MEMORANDUM

Subject: Application ID: 2013-187

Comments Submitted by: Marge Schmuckal/Zoning on 11/8/2013

1 SOUTH ELEVATION
A-201 SCALE: 1/4"=1'-0"

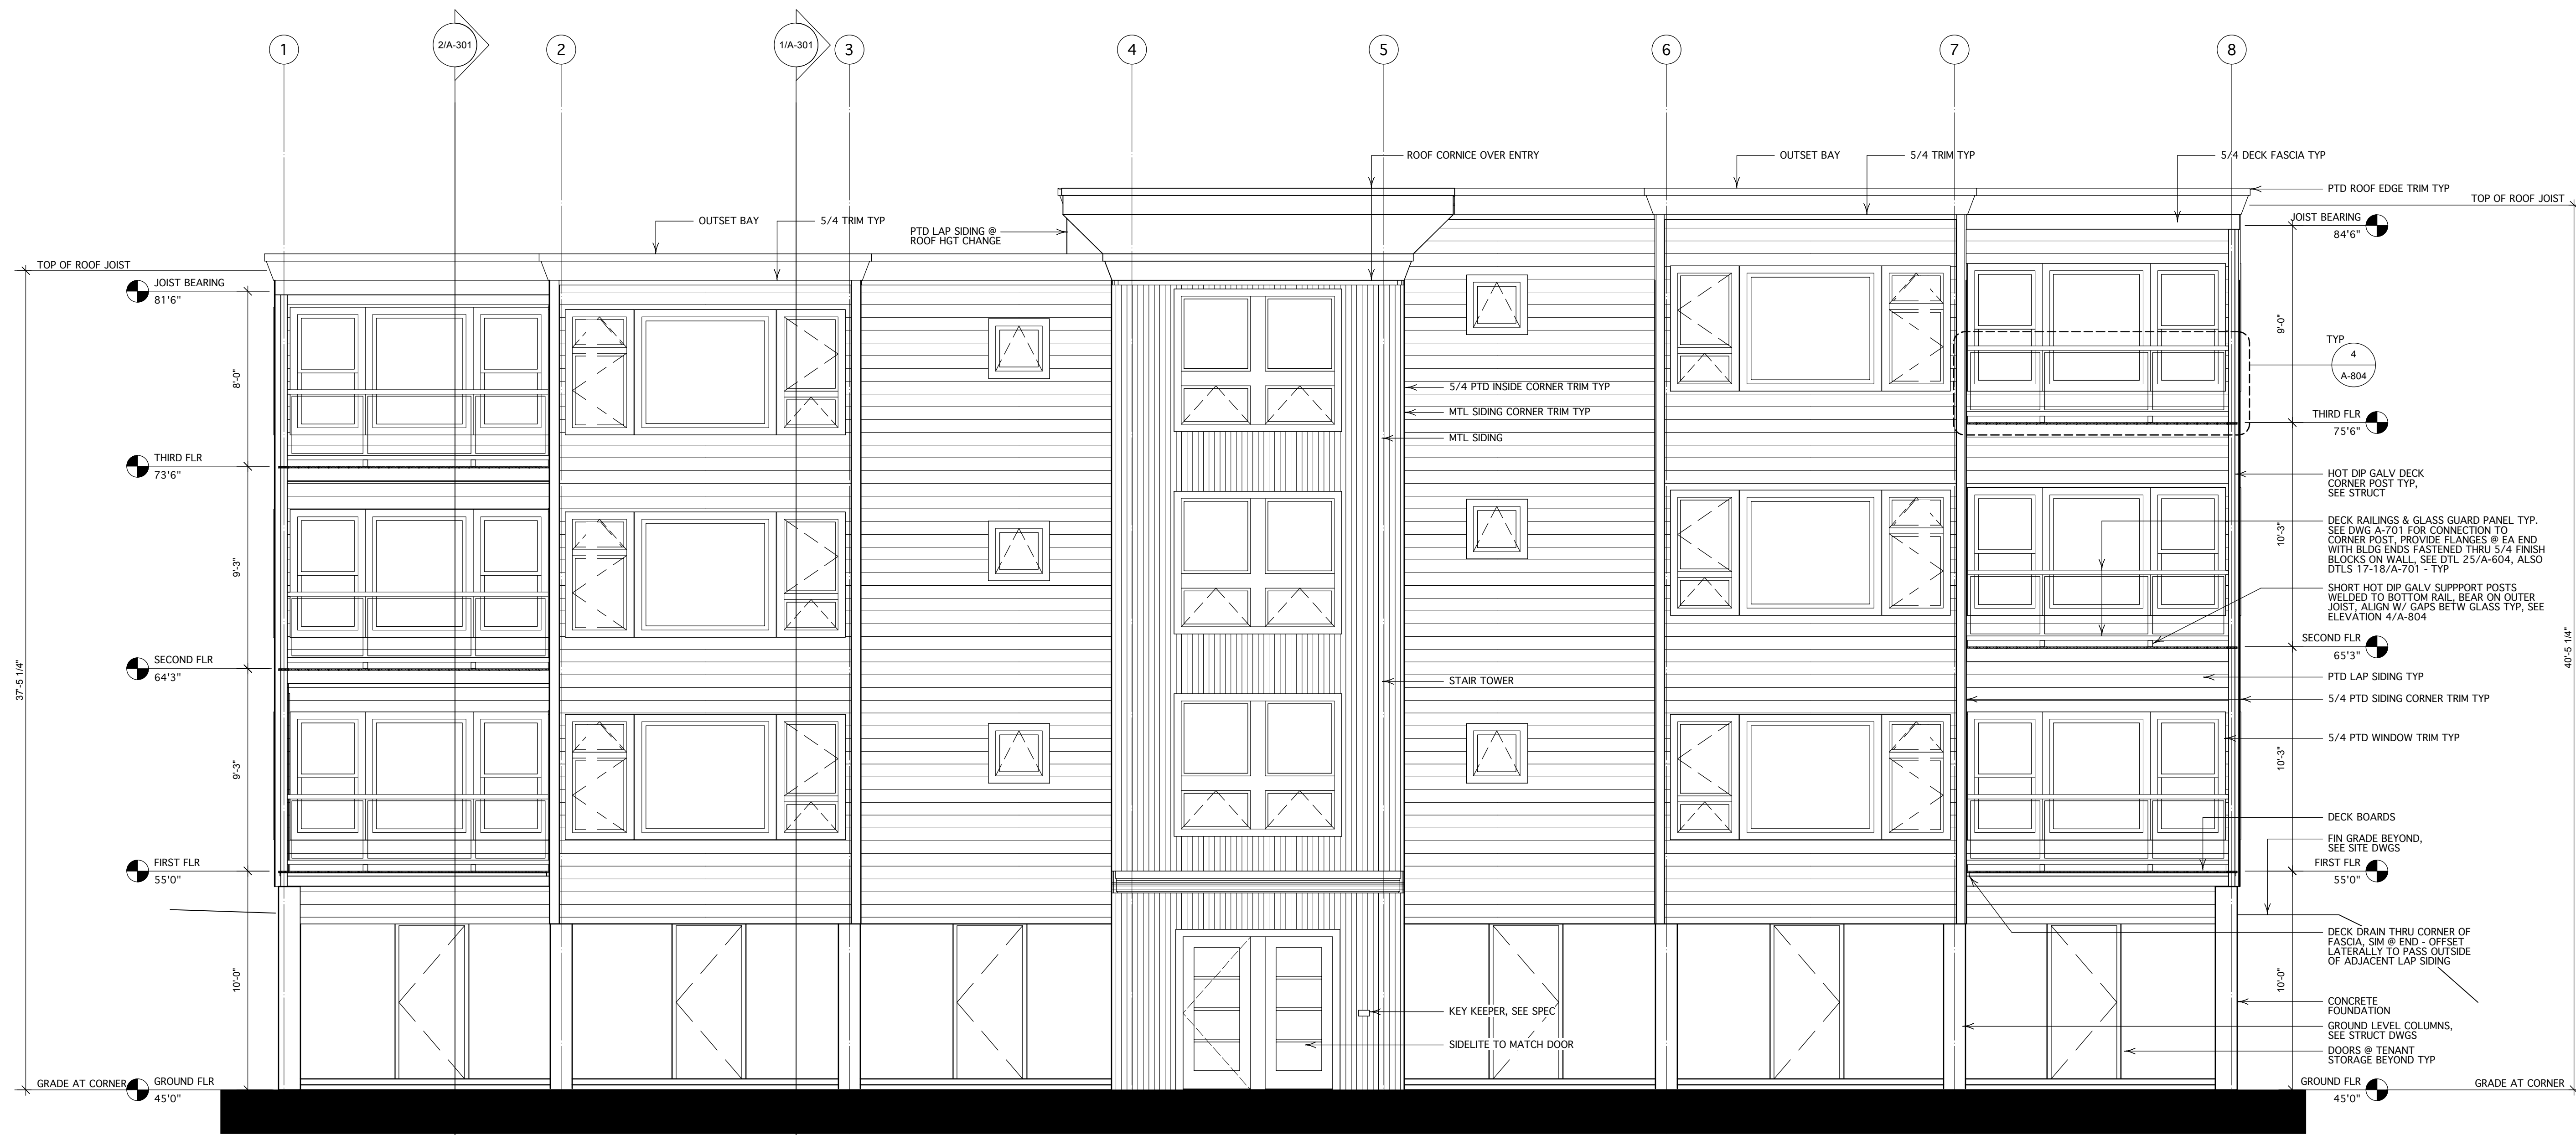
I have reviewed the most current plans that have been submitted for building height. Section 14-139(a)7 of the R-6 zone restricts the maximum building height to 45'. The applicant has shown the height from the lowest grade to the top of the roof beam to be 40' -5 1/4". This is the height BEFORE averaging grades, which would lower the "official" height of the structure. The 40'- 5 1/4" is well under the maximum height allowed by Ordinance. The building height is ok for the zoning analysis.
